DECISION DELEGATED TO HEAD OF PLANNING

Application No: H02-0808-24 **Applicant:** Mr R Finch
Proposal: Proposed Extension to Dwelling
Location: 21 Chapel Street Crowland
Terminal Date: 20th November 2024

PROPOSED
FIRST FLOOR PLAN 1:50

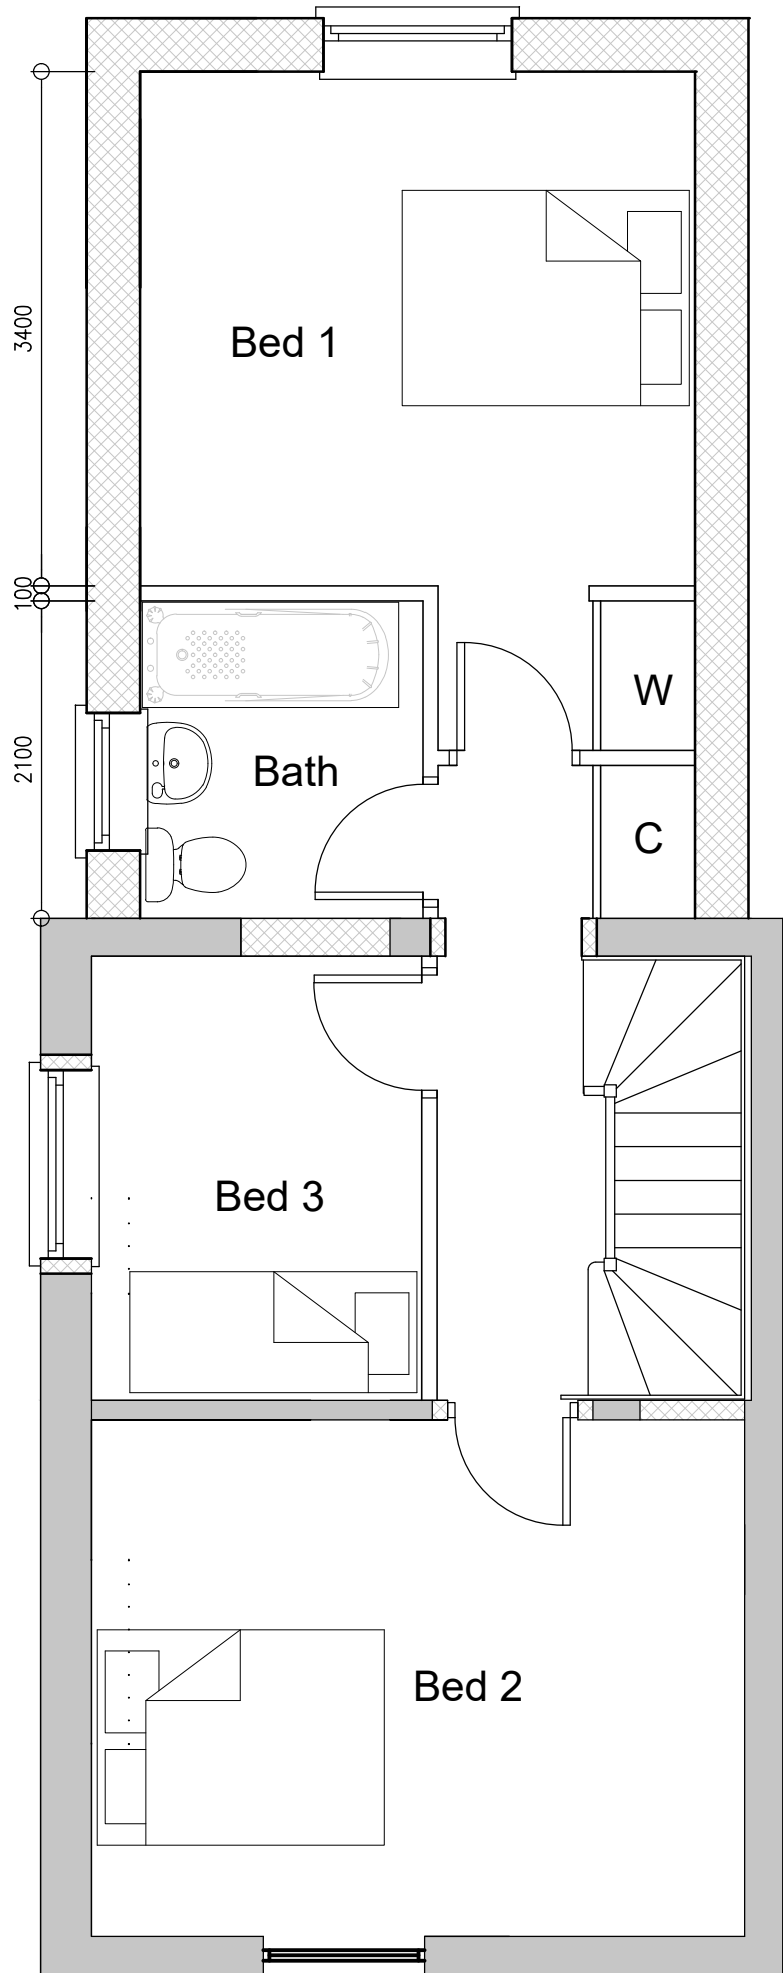
The first floor side window will operate for a shared bathroom, this should be obscure glazed due to the nature of the room and therefore should not materially overlook - a condition will be imposed on the decision notice should the application be approved to ensure this remains.

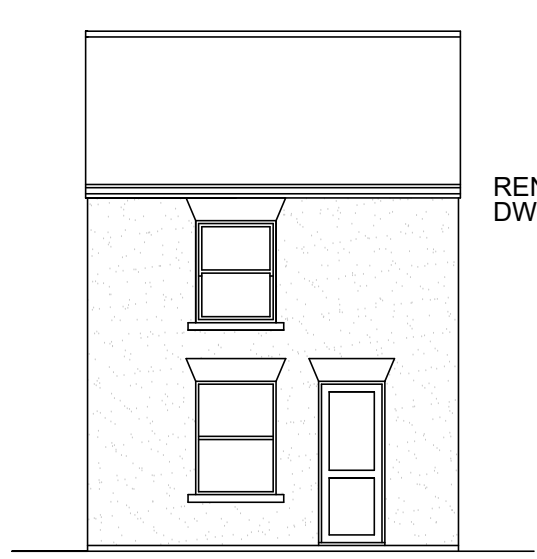
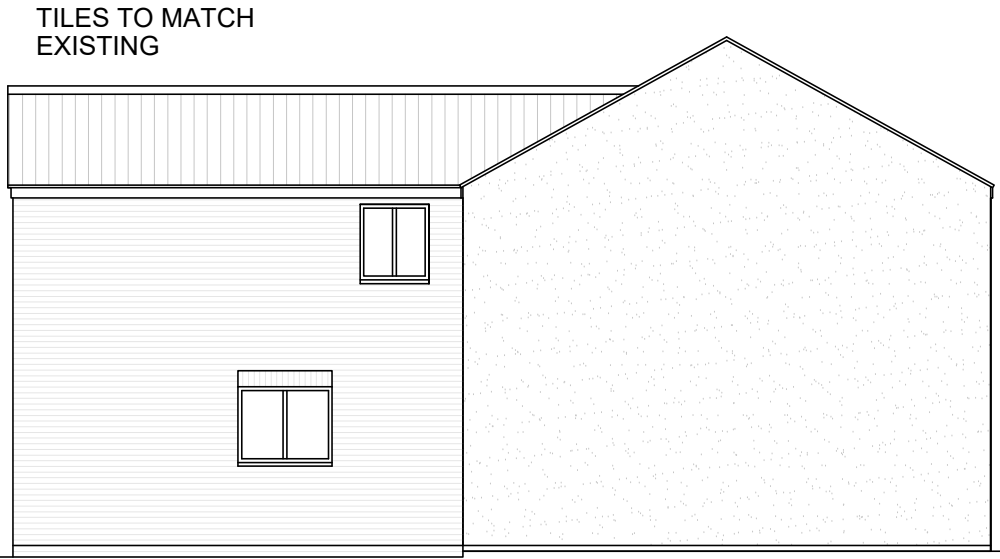
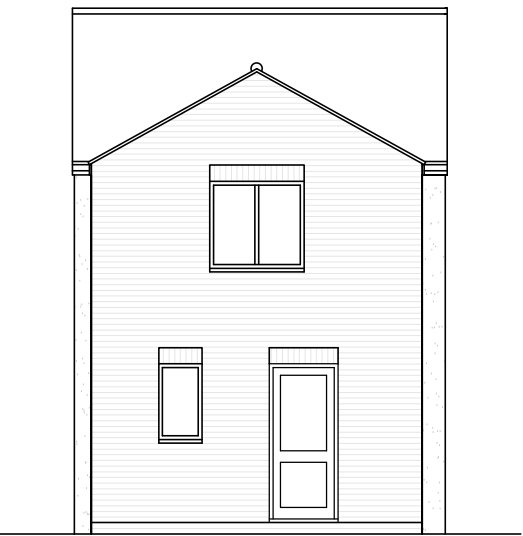
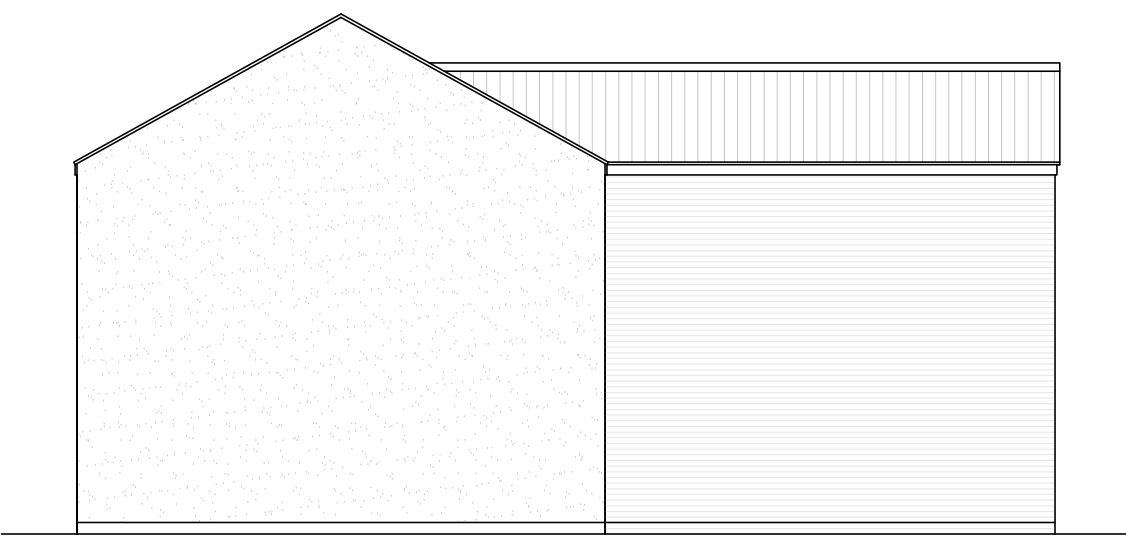
Proposed elevations are listed incorrectly, Side elevation is the front, Rear elevation is the side and front elevation is the back. Comments:- CPC no comments.

PROPOSED SITE PLAN 1:200

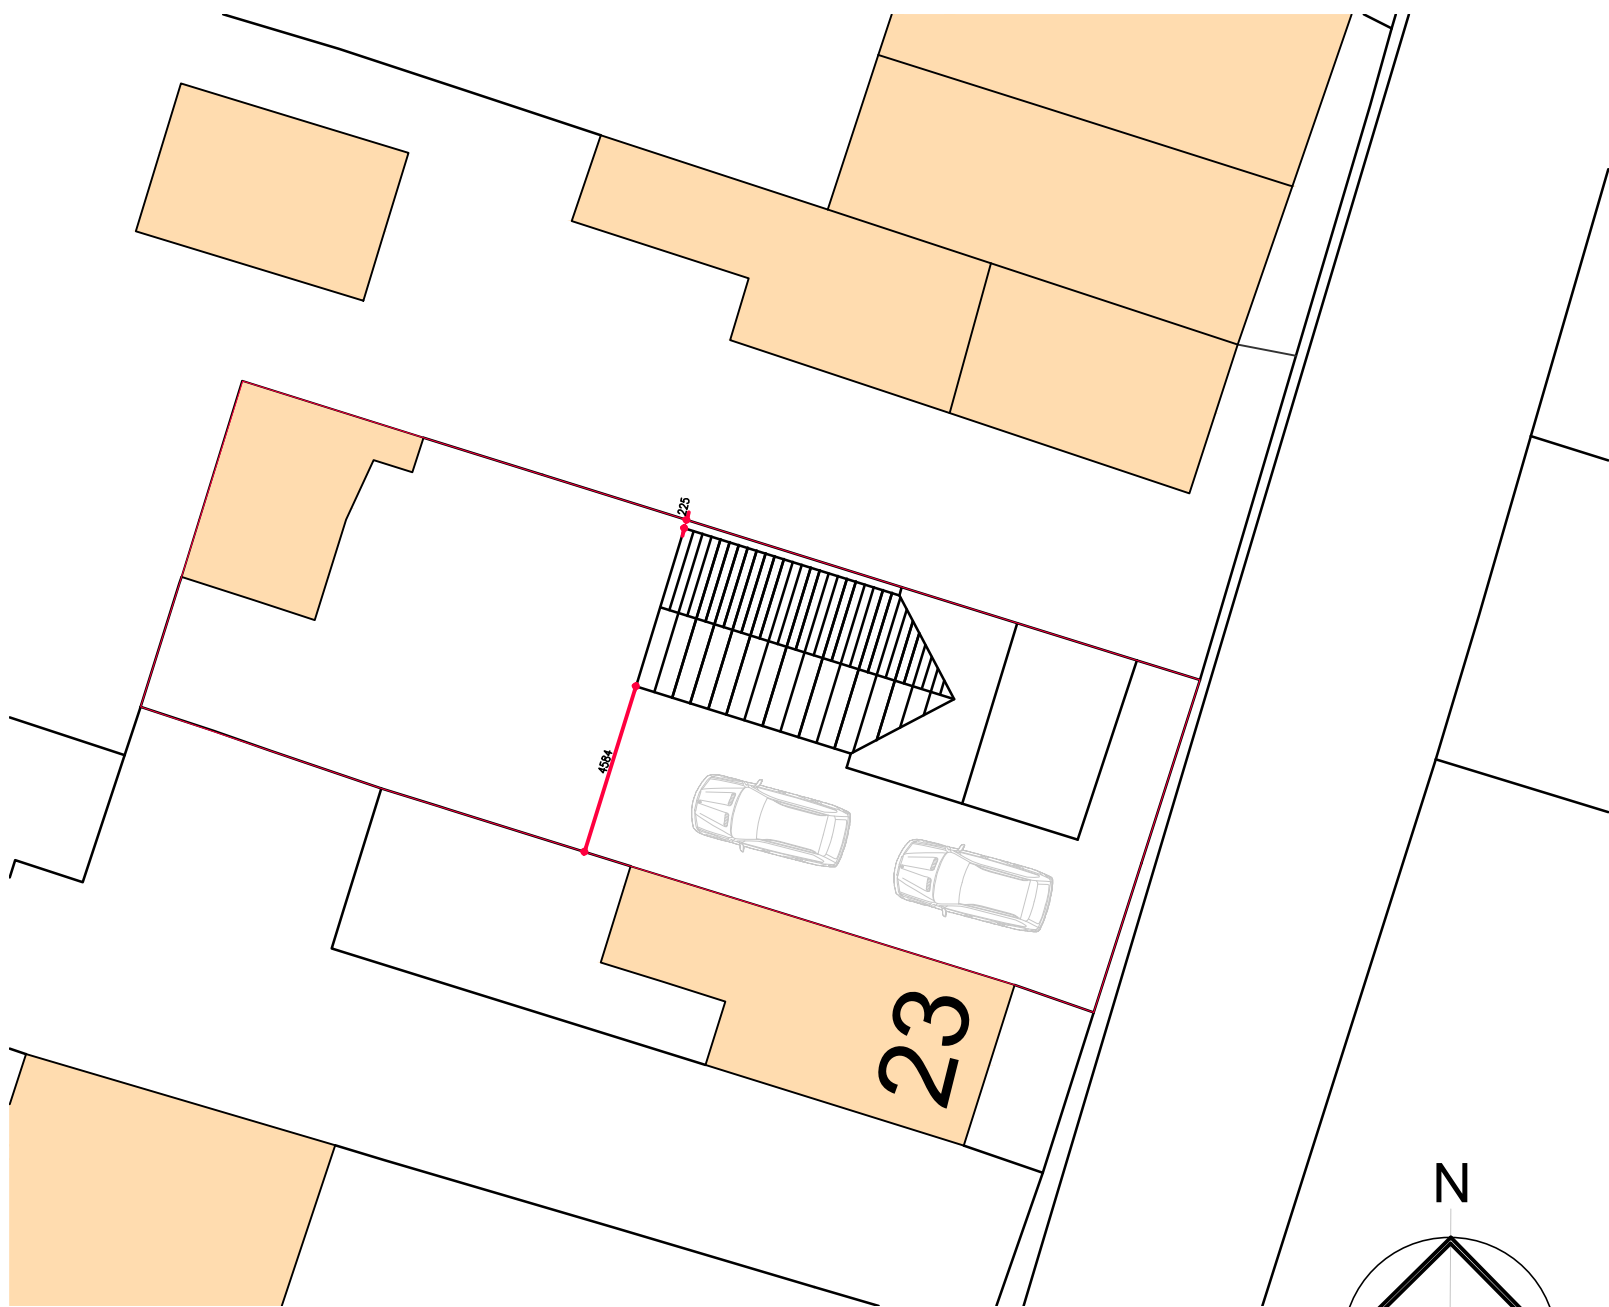
There is an increase in one bedroom within the dwelling taking it from no. 2 to 3. The site therefore needs to present at least two vehicle spaces for off street parking, this has been clearly demonstrated within the proposed site plan and therefore the application in this instance is considered to be in accordance with Appendix 6.
